**KIRKLEES METROPOLITAN COUNCIL
INVESTMENT & REGENERATION SERVICE**

DELEGATED DECISION TO DETERMINE PLANNING APPLICATIONS

Reference No:	2023/62/93462/E
Site Address:	11&13 Lees Avenue, Thornhill Lees, Dewsbury, WF12 0AN
Description:	Erection of single storey front extension, two storey rear extension and front and rear dormers with hip to gable roof and external alterations
Recommending Officer:	Elenya Jackson

DECISION - REFUSED

PROPOSED
FRONT ELEVATION

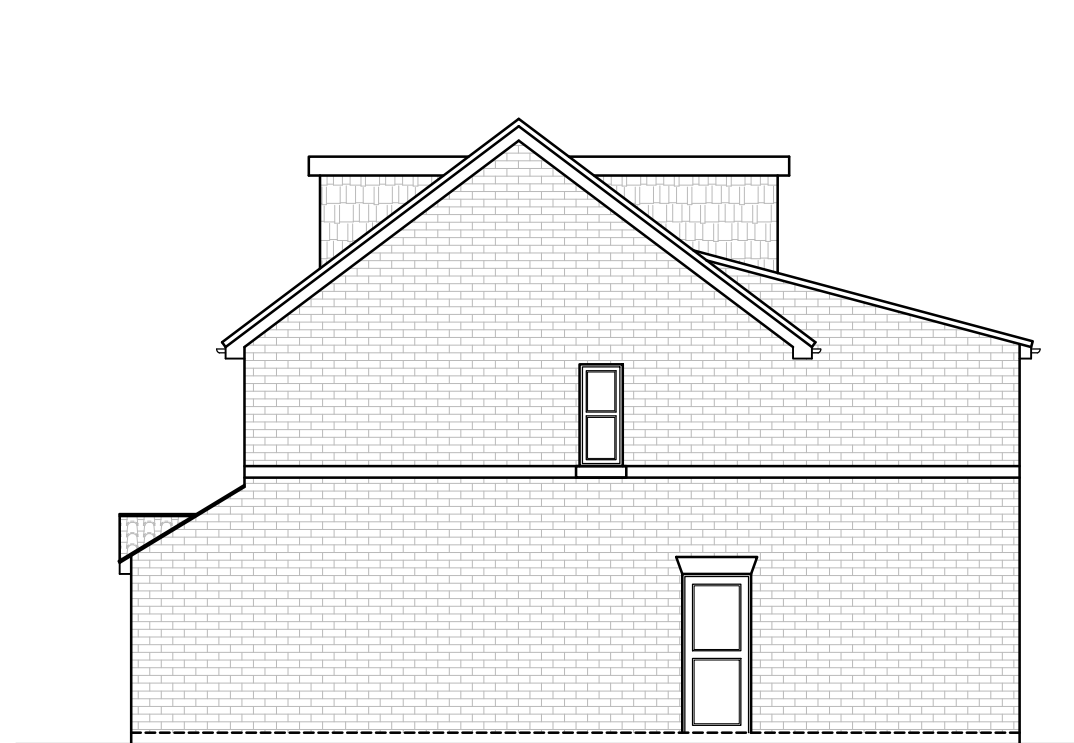
The proposal also includes dormers to the principal elevation of the dwelling, section 5.4 refers to dormers to the front of properties and states that, to assess whether a dormer window is appropriate on the front elevation, consideration should be given to the surrounding buildings in the street, they may be acceptable if they are characteristic of the street scene. During the site visit, officers looked at the building group and immediate street scene and no dormers to the principal elevation of dwellings were visible. Therefore, it is considered that the introduction of dormers into the principal elevation of the dwellings in this location would be out of keeping with the host property and prevailing character of the area.

Having taken the above into account, the proposed roof alteration & dormer to no.13 and the introduction of dormers to the principal elevation of both dwellings would result in the formation of an incongruous feature which would be out of character with both the host dwelling and the wider street scene. The proposals therefore fail to comply with Policy LP24 of the Kirklees Local Plan (a) in terms of the form, scale and layout, KDP 1 & 2 of the House Extensions & Alterations SPD and the aims of chapter 12 of the National Planning Policy Framework.

1. The proposed roof design, rear dormer and two front dormers would result in the formation of an incongruous feature which would be out of character and detrimental to the host property and the wider area. To permit the proposals would be contrary to Policy LP24 of the Kirklees Local Plan, KDP1 & KDP2 of the House Extensions & Alterations SPD and advice within Chapter 12 of the National Planning Policy Framework.

PROPOSED
REAR ELEVATION

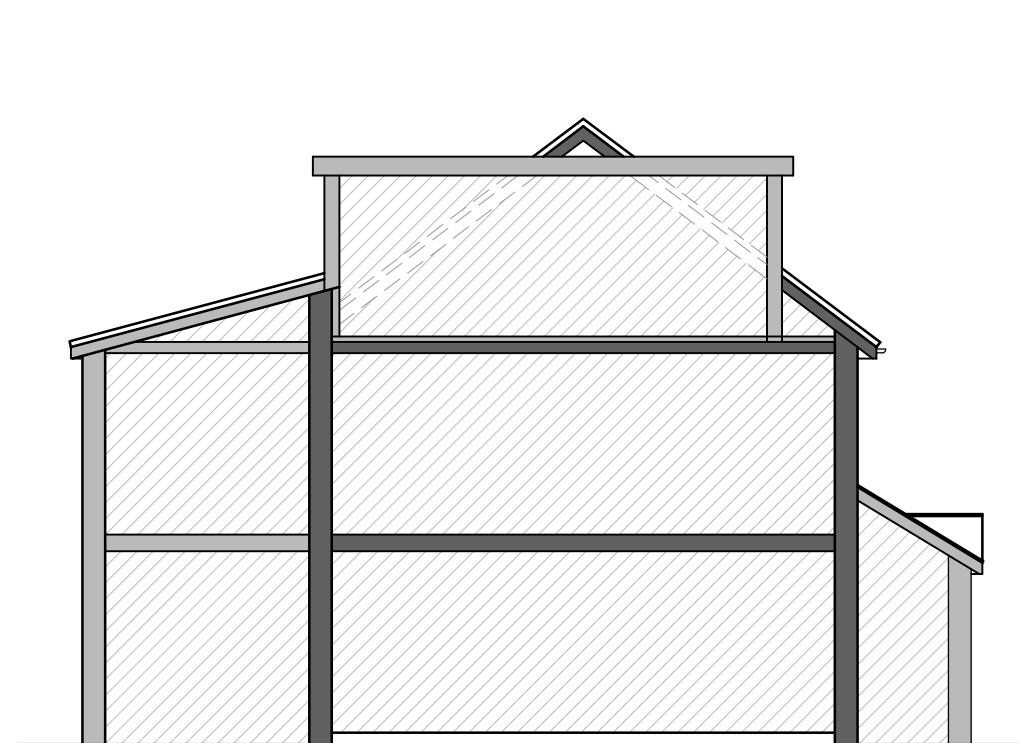
In point 5.25 of the House Extensions & Alterations SPD, it suggests that rear dormers can be considered to be appropriate dependent upon design and size. The rear dormers would be a box like structure built out of the roof plane. It is considered that both dormers to the rear of the properties would not dominate the roof space and would be clad with vertically hung tiles which would soften the impact on the roof scape. That being said, the dormer to no.13 would rely on the hip to gable enlargement, which has been considered above as unacceptable in terms of visual amenity.

Overshadowing/loss of light: The extension would be constructed along the shared boundary with No.9 and as such would have an overbearing and oppressive impact. Furthermore, the neighbouring no. 7 has their own extension. As such, the proposed extension at the rear of 11 would enclose the rear elevation of the adjoining dwelling. Therefore, it is considered that the proposal would have a significantly harmful effect for the occupiers of no.9 in terms of overbearing.

2. The proposed extension to the rear of 11 Lees Avenue, would by reason of its projection and position along the shared boundary, result in an overbearing and oppressive impact on the rear windows and amenity space to the detriment of the occupants of the adjoining 9 Lees Avenue. To permit the proposals would be contrary to Policy LP24 of the Kirklees Local Plan, KDP6 of the House Extensions & Alterations SPD and advice within Chapter 12 of the National Planning Policy Framework.

PROPOSED
ROOF PLAN

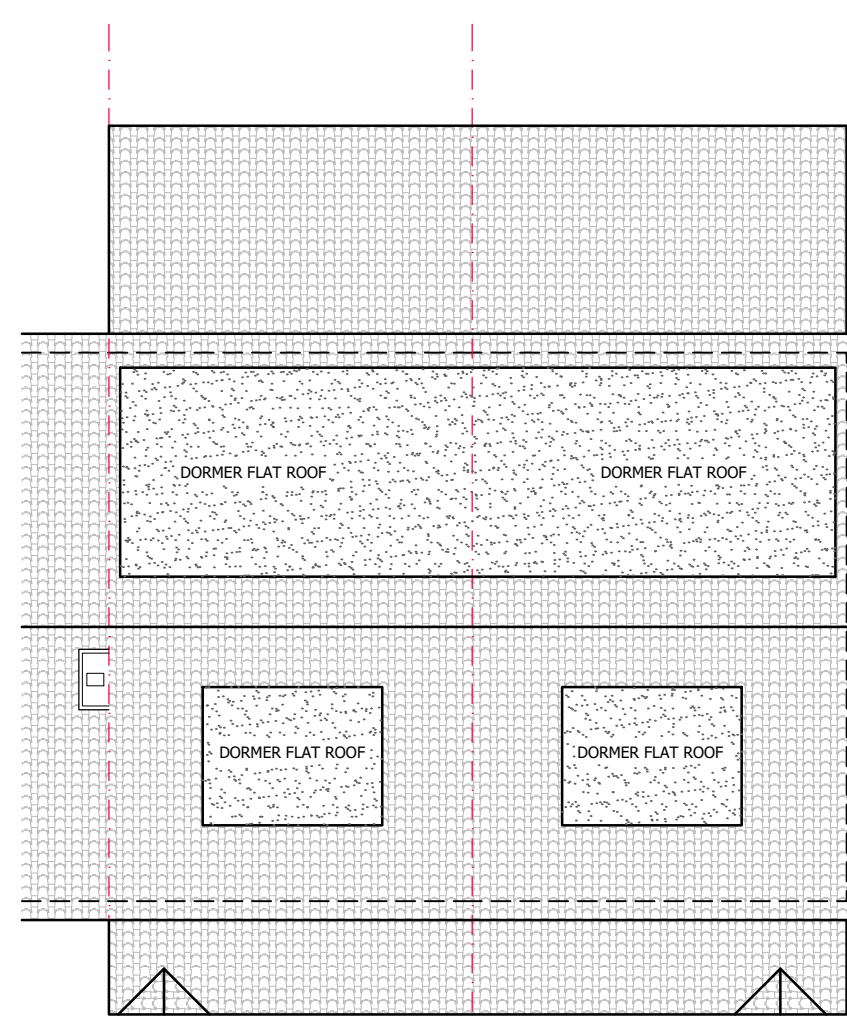
The properties within Lees Avenue, Lees Holm, Parker Drive are almost entirely hipped roofed properties. The alteration of the roof to a gable of no.13 would appear out of character with the host property and result in an incongruous and out of keeping feature within the street scene. The proposed hip to gable enlargement is therefore not considered to be acceptable in terms of visual amenity.
